**RE: Blake's Lotaburger #64
1801 Juan Tabo Blvd. NE
Grading and Drainage Plan
Engineer's Stamp Date: No Stamp Date
Hydrology File: H21D012**

Based upon the information provided in your submittal received 04/25/2019, the Grading & Drainage Plan **is not** approved for Building. The following comments need to be addressed for approval of the above referenced project:

C1A

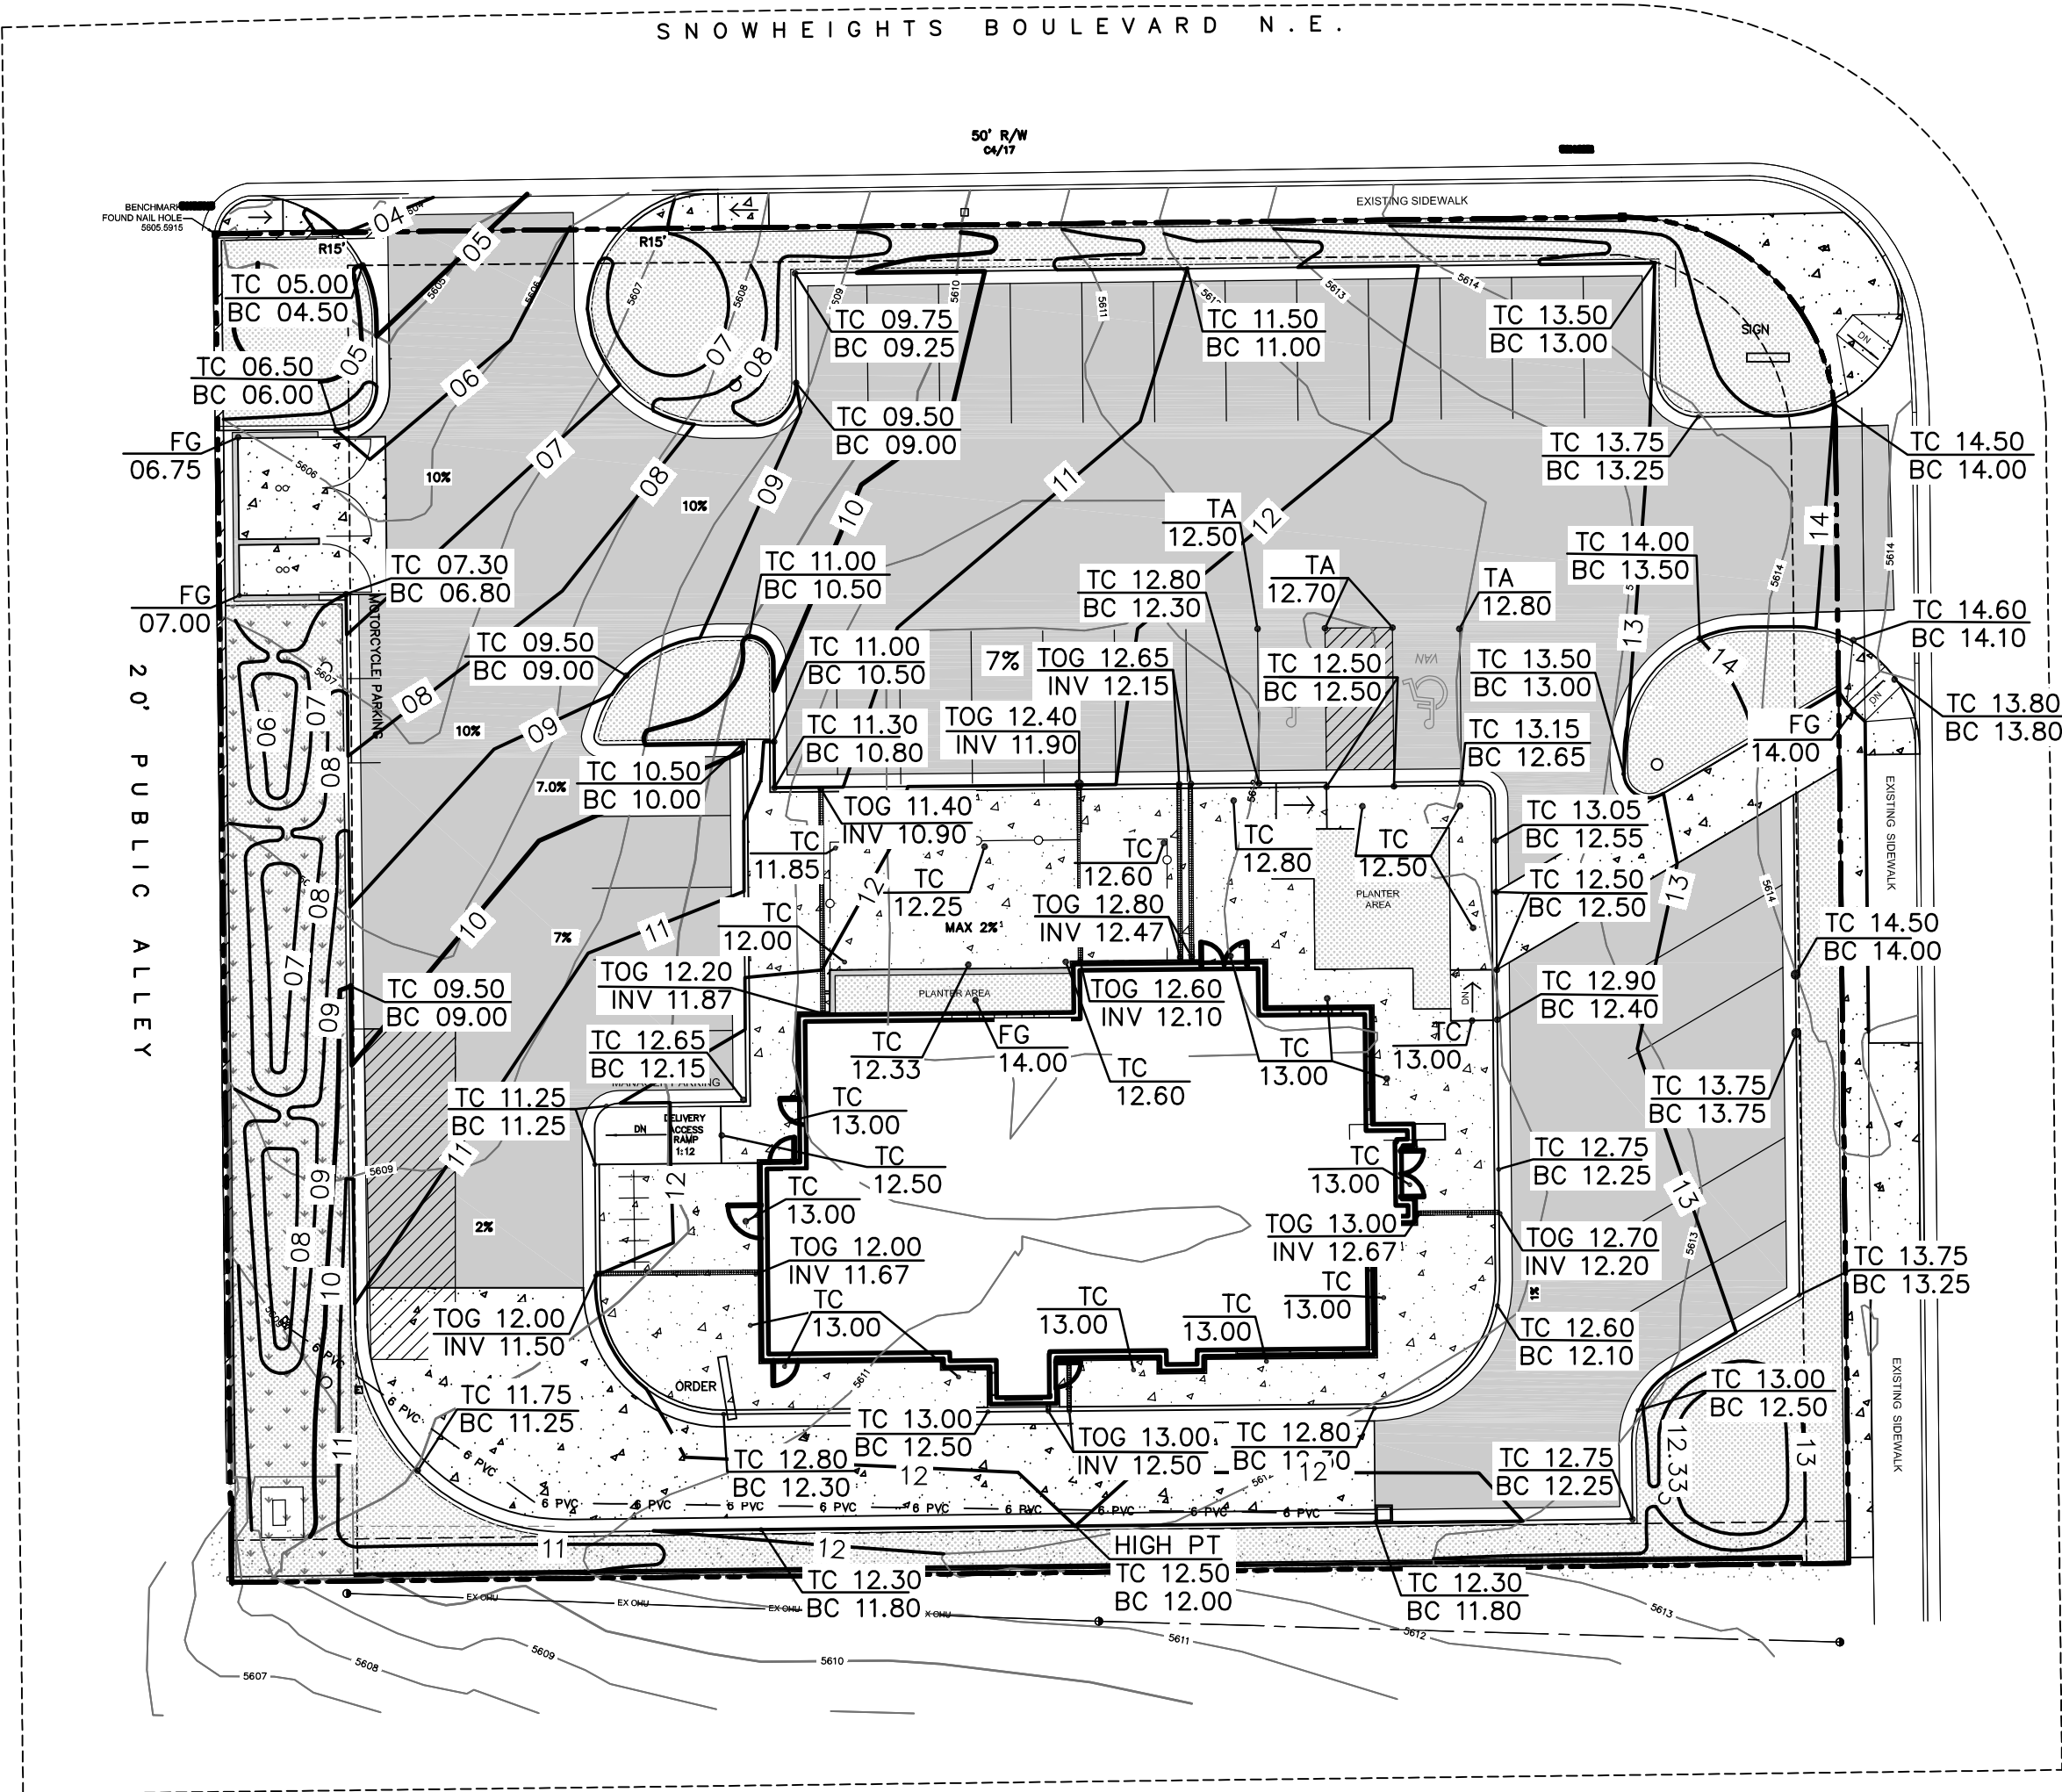
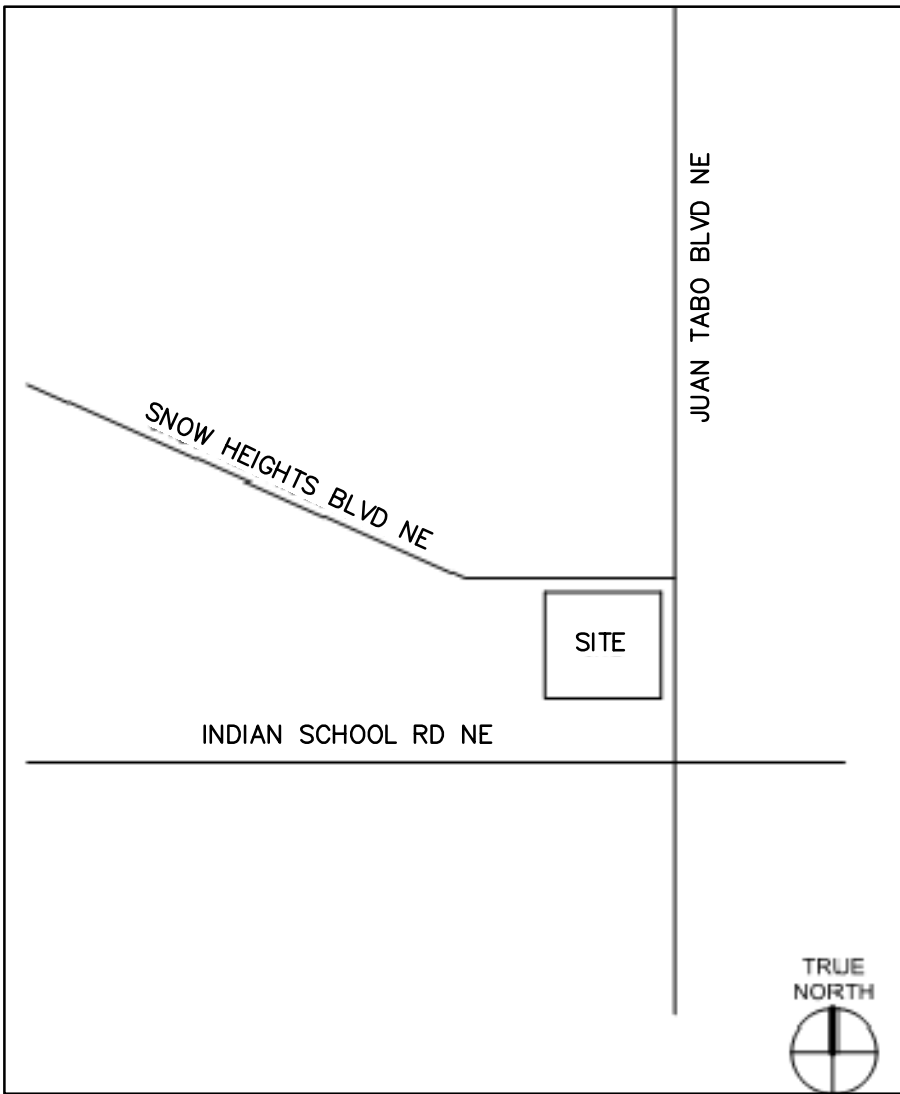
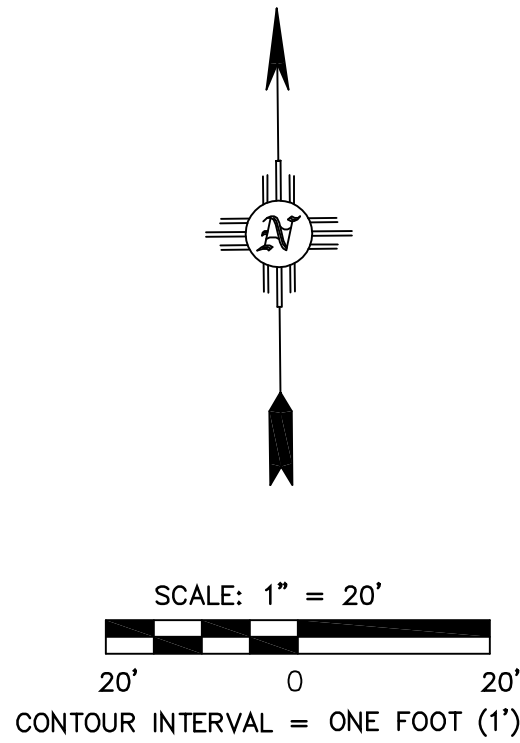
1. Please provide an engineer's stamp date.
2. Please provide all missing information from the Grading Plan Checklist. (c, d, e, & f) Per the DPM Chapter 22 Section 7 - Grading Plan Checklist, the following must be on the Grading Plan.

- a. Please provide an engineer's stamp with a signature and date.
 - b. Please use 1" = 20' for the scale.
 - c. Please provide a Vicinity Map.
 - d. Please provide the Benchmark information (location, description and elevation) for the survey contour information provided.

- e. Please provide the FIRM Map and flood plain note with effective date.
 - f. Please provide a legal Description of the property.
3. Please use the procedure for 40 acre and smaller basins as outlined in Chapter 22, Part A of the Development Process Manual (DPM). Please provide both the existing conditions and proposed conditions for the 100 year-6 hour storm event. See Attached pdf (this is a draft of the DPM update). This site is in Precipitation Zone 4.

4. The storm water quality (SWQ) volume for this site is required in order to manage the storm water runoff. Since this is a redevelopment site, the storm water quality volume is calculated based on the 0.48 inch storm. To calculate the required storm water quality volume to be captured, multiply the impervious area by 0.28 inches for the 80th

percentile storm. This required storm water quality volume can be captured within the depressed areas of the landscaping. Please also state the total provided storm water quality volume for the site.

5. Please label each storm water quality pond with the provided SWQ volume.
6. Please provide the weir calculations for the curb cuts per the DPM. A coefficient of 2.7 is typically used for the equation $(6.60) Q = CLH^{2/3}$.
